DOC19/995044-9; EF 14/502 (CSSI 9837)

**Newcastle Power Station Project - (CSSI 9837)- Environmental Impact Statement
Review by the Environment Protection Authority**

ATTACHMENT A – EPA additional information requirements

Figure 7.10: 99.9th percentile incremental 1 hour average acrolein predictions – Reciprocating Engine Option ($\mu\text{g}/\text{m}^3$)

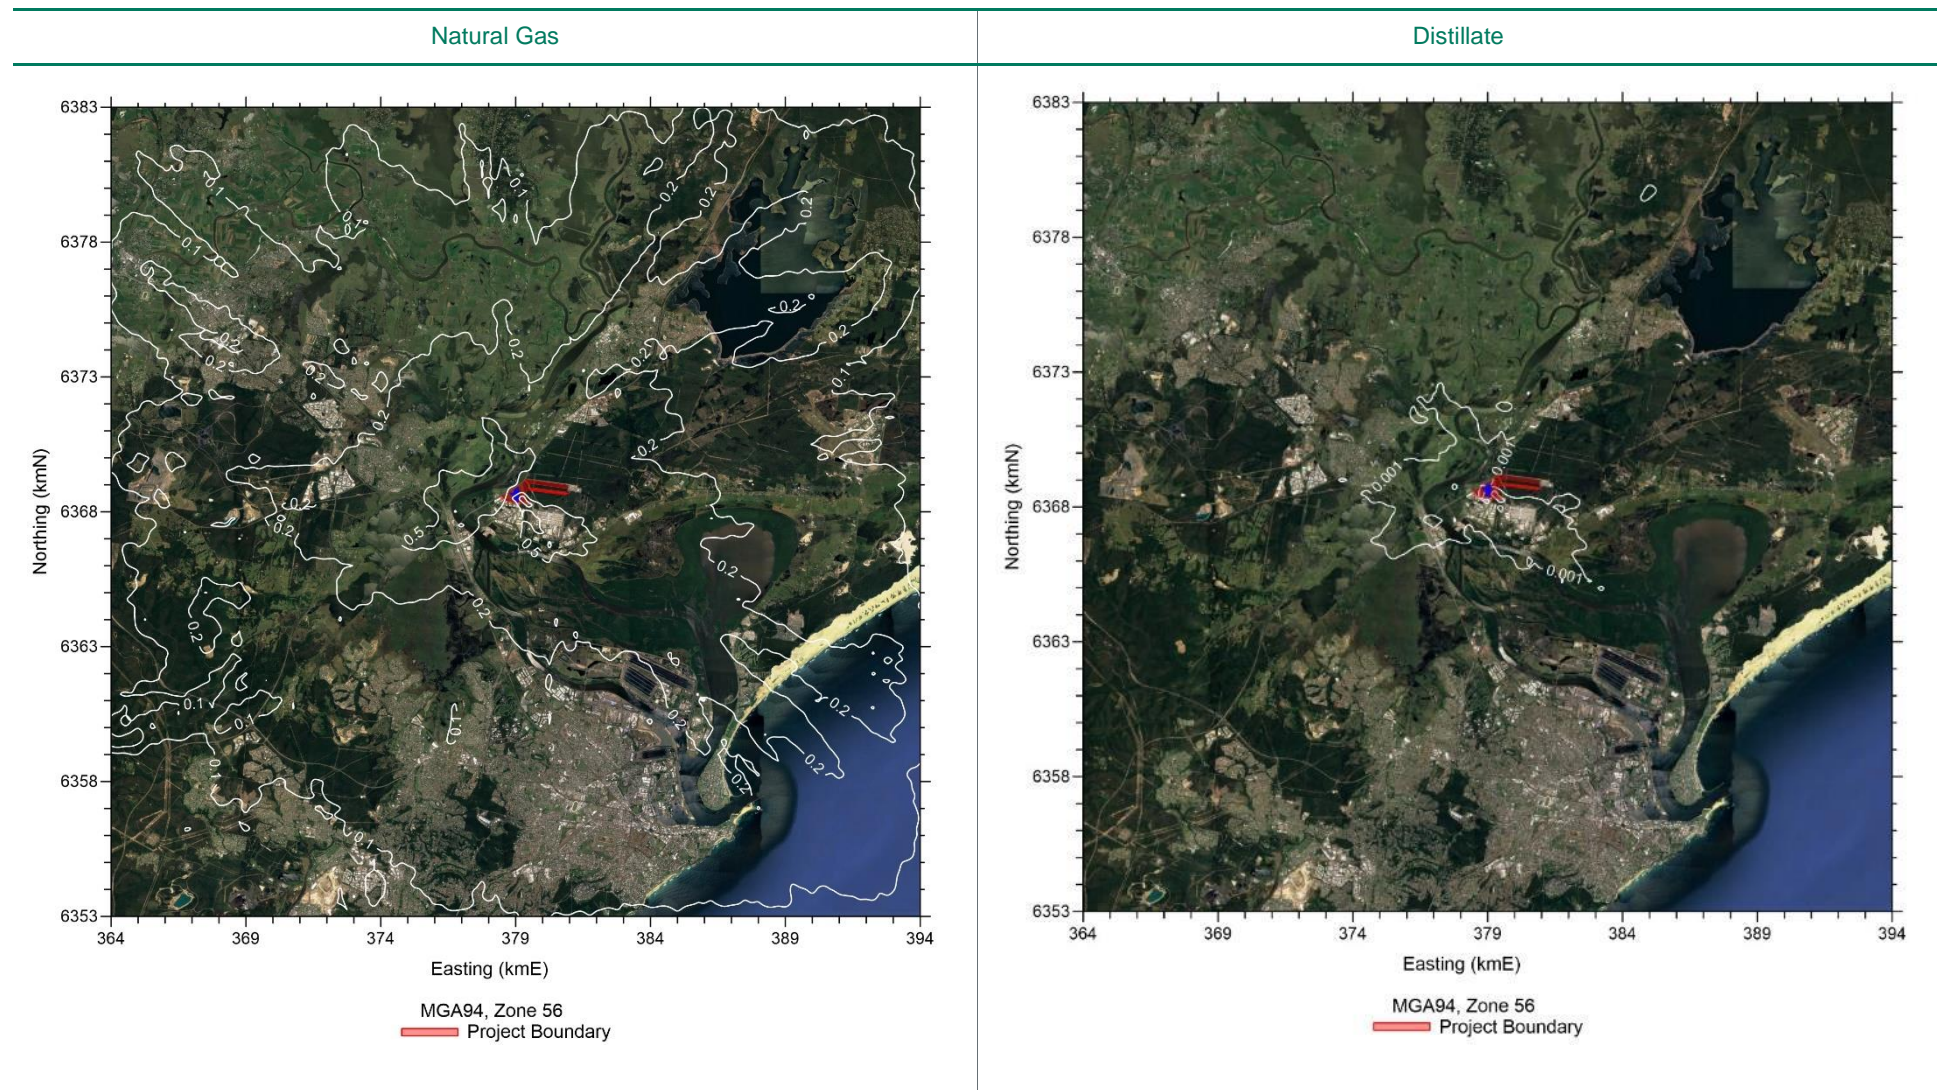
The proposed option of the reciprocating engine using natural gas exceeds the Impact Assessment Criteria (IAC) of $0.42 \mu\text{g}/\text{m}^3$ for acrolein at the two nearest discrete receptors ($0.68 \mu\text{g}/\text{m}^3$) and beyond the boundary ($1.25 \mu\text{g}/\text{m}^3$). These exceedances occur with a 40 % control efficiency applied which has been estimated from the manufacturer. Robust justification for the assumed control efficiency has not been provided.

Acrolein is classified as a principal toxic air pollutant. The *Approved Methods for the Modelling and Assessment of Air Pollutants in NSW* requires that principal toxic air pollutants be minimised to the maximum extent achievable through the application of best-practice process design and/or emission controls.
